**Consultation Response from KC,  
Trees**

**2023/93539 Land adj, Ledgard Bridge Mill, Back Station Road, Mirfield, WF14 8NZ**

**Date Responded: 25/04/2024**

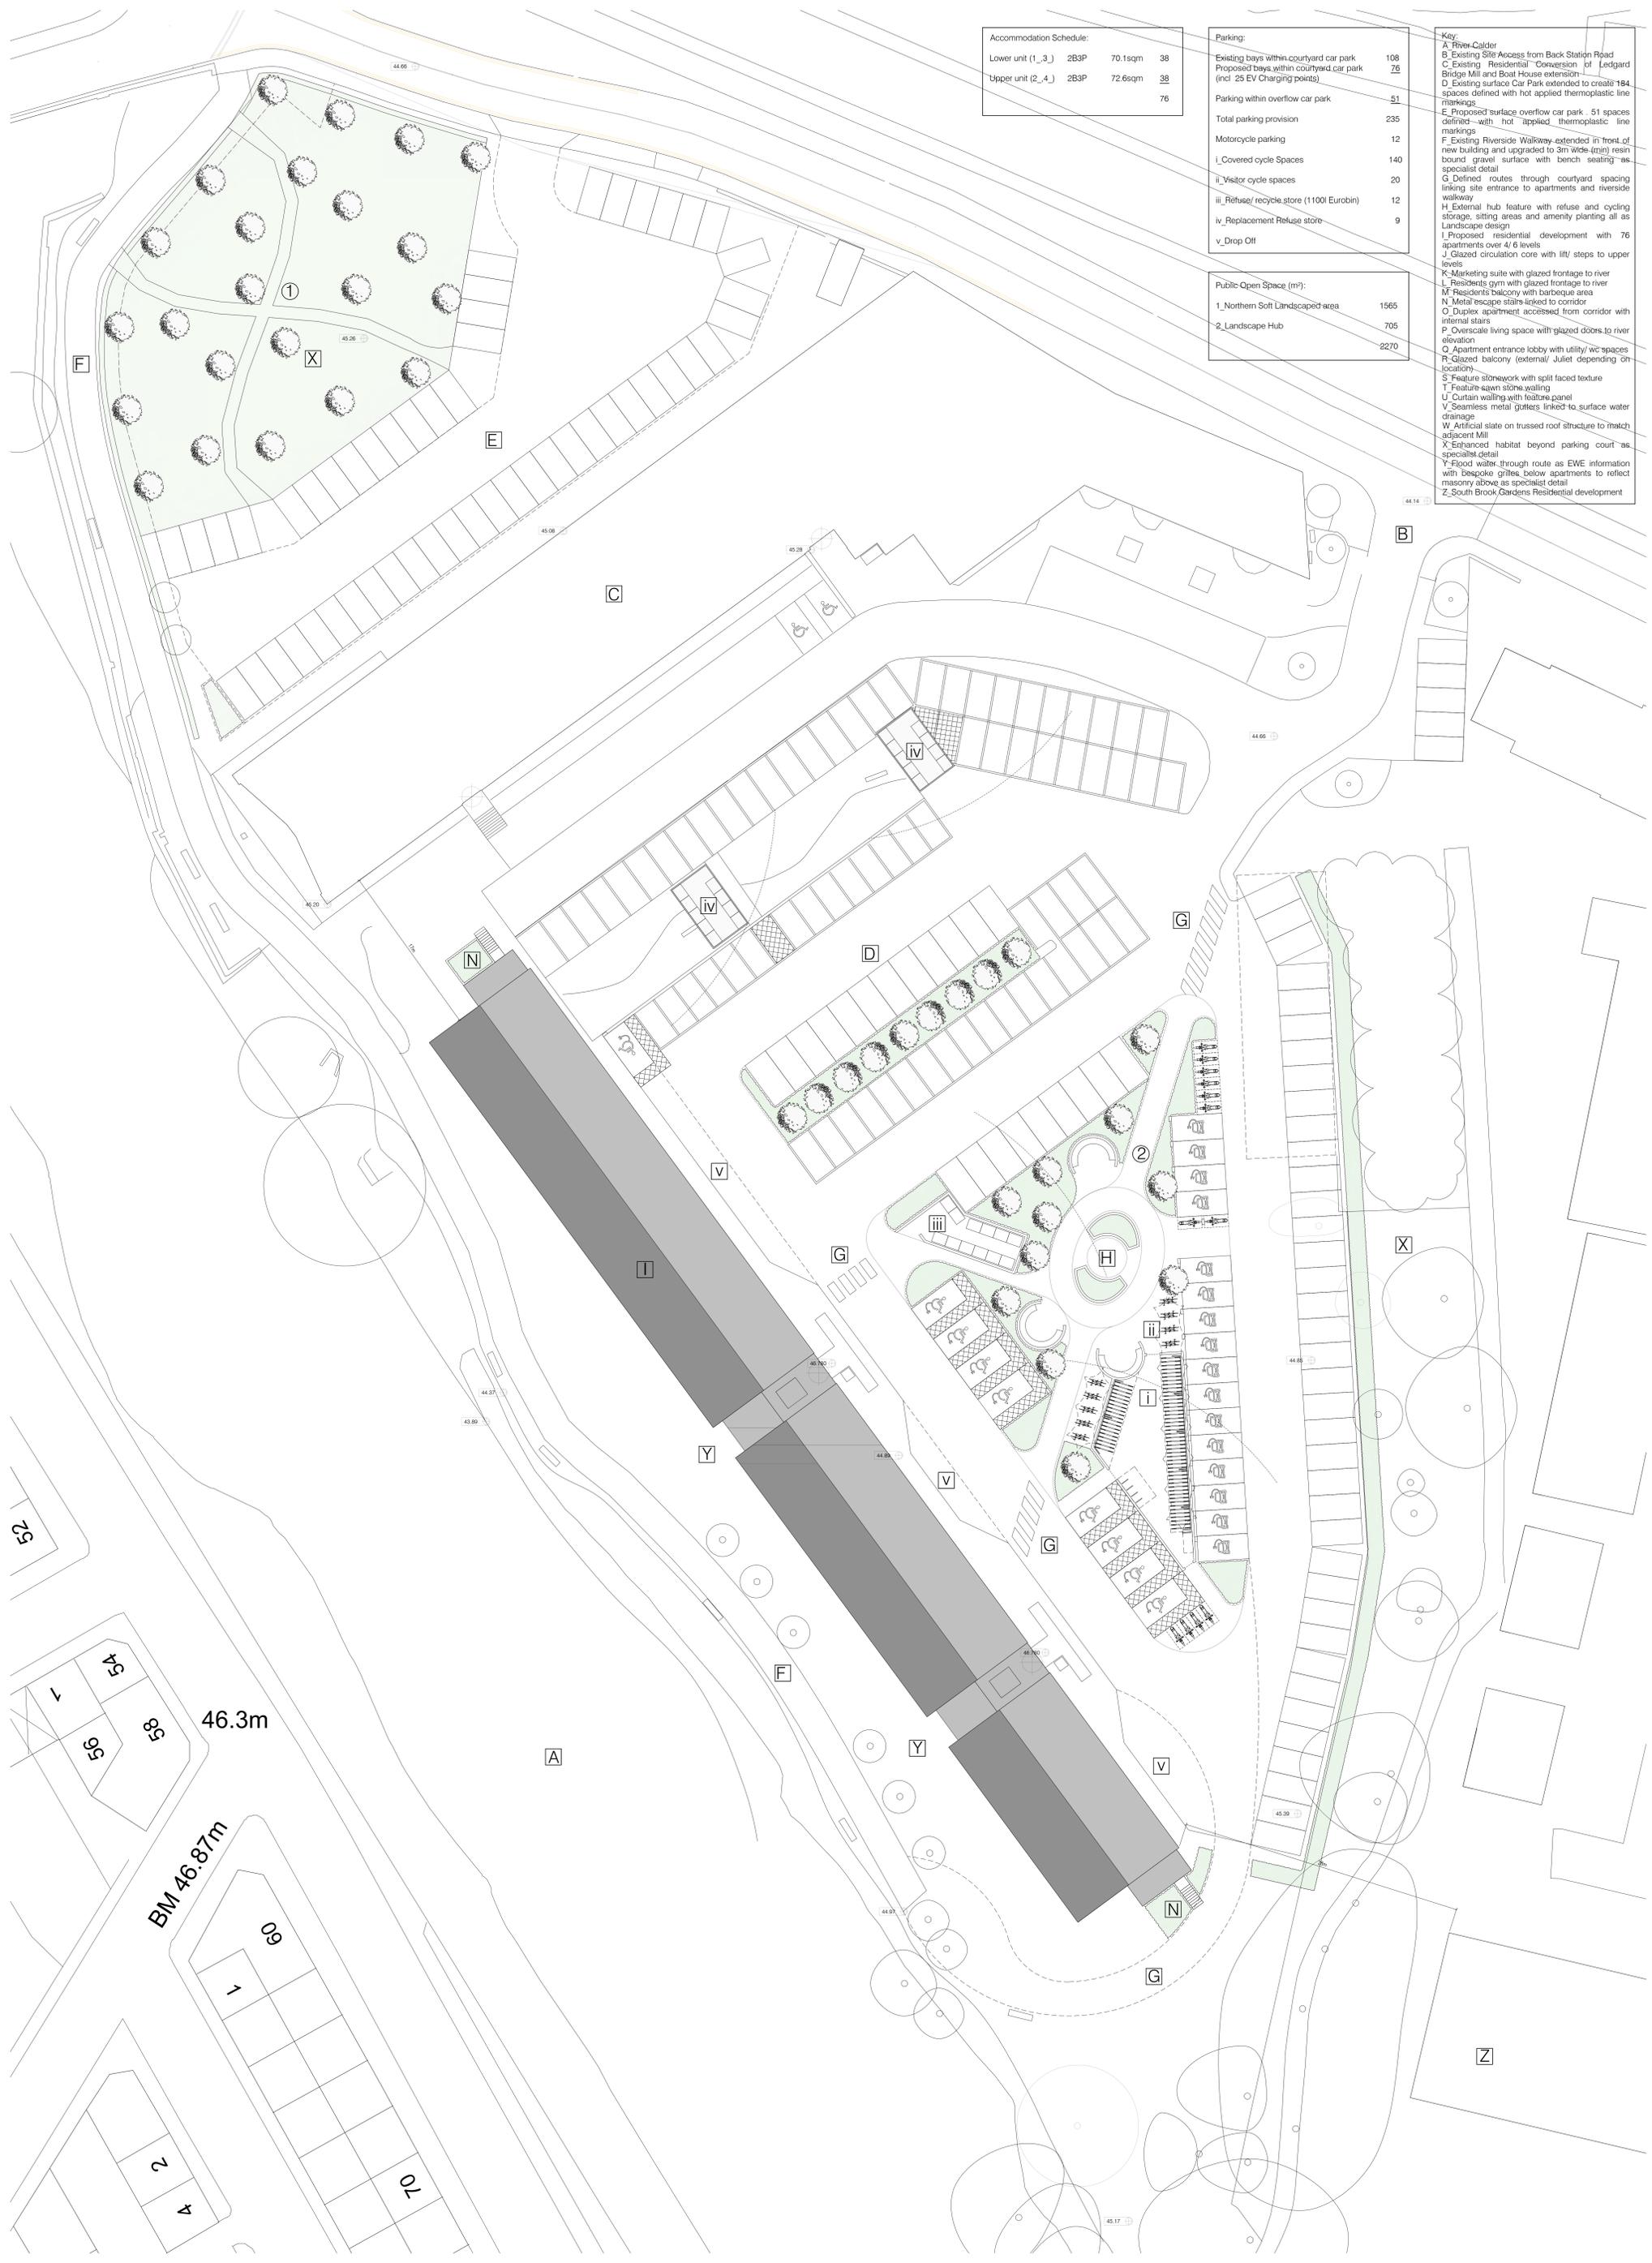
KC Trees would encourage including more new tree/shrub and hedge planting within the car parking area itself, to help break it and provide some valuable shade to the parked cars in the summer.
